**From:** Christina Wollman  
**Sent:** Thursday, February 19, 2015 3:19 PM  
**To:** Kaycee Hathaway  
**Subject:** RE: Notice of Application: AU-14-00003 Harrell & Sons Farm

**Subject:** Notice of Application: AU-14-00003 Harrell & Sons Farm

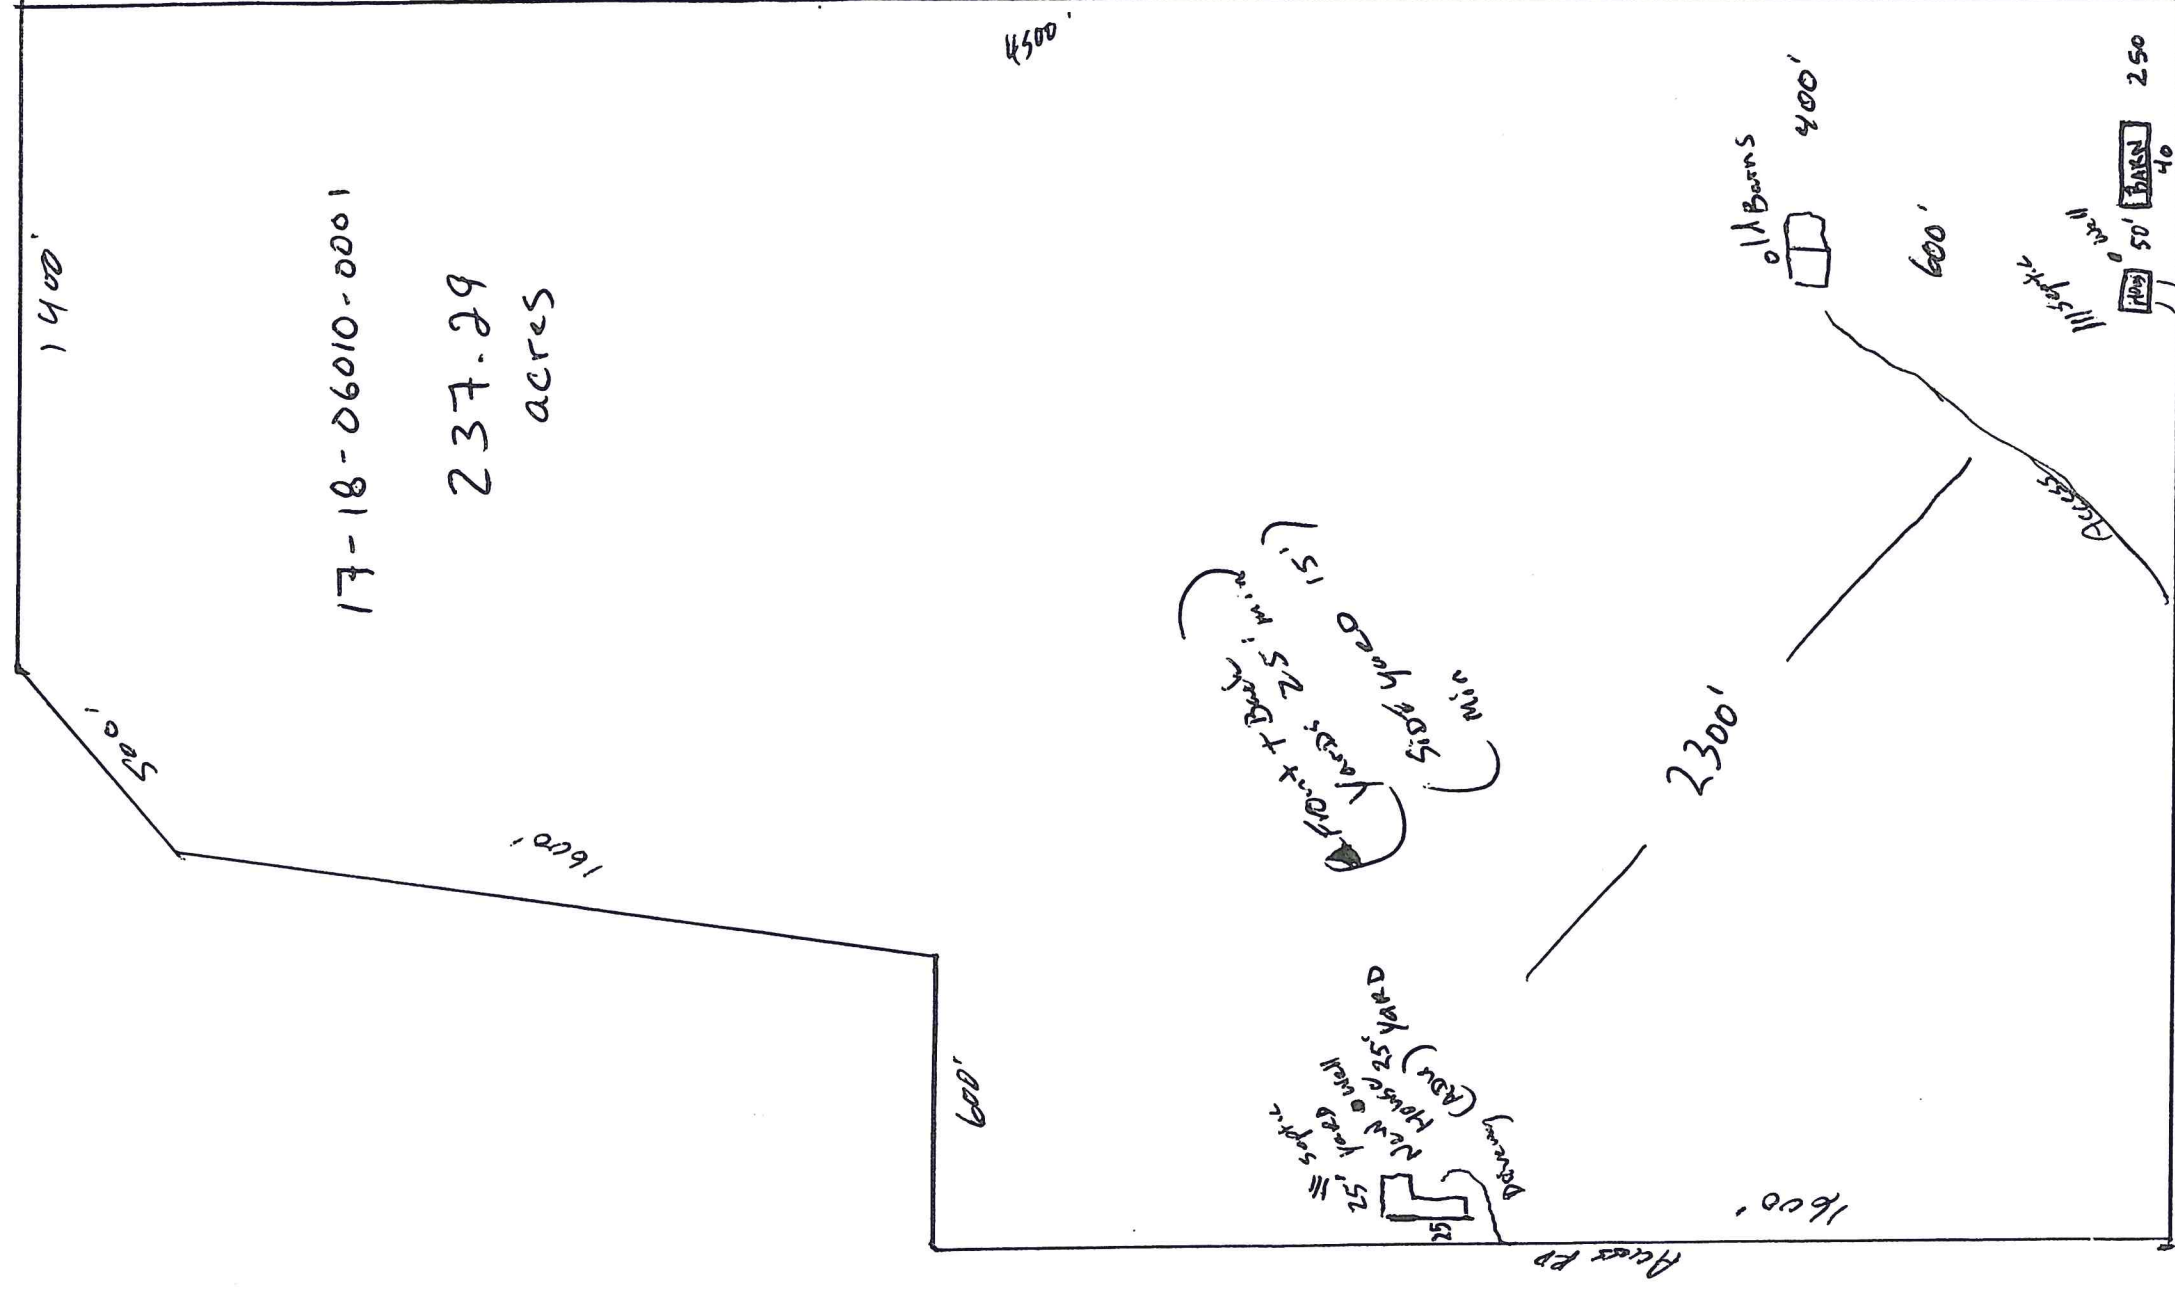
The landowner will need to apply for an address and as shown in the site plan, will be required to use the existing access from Hanson Road.
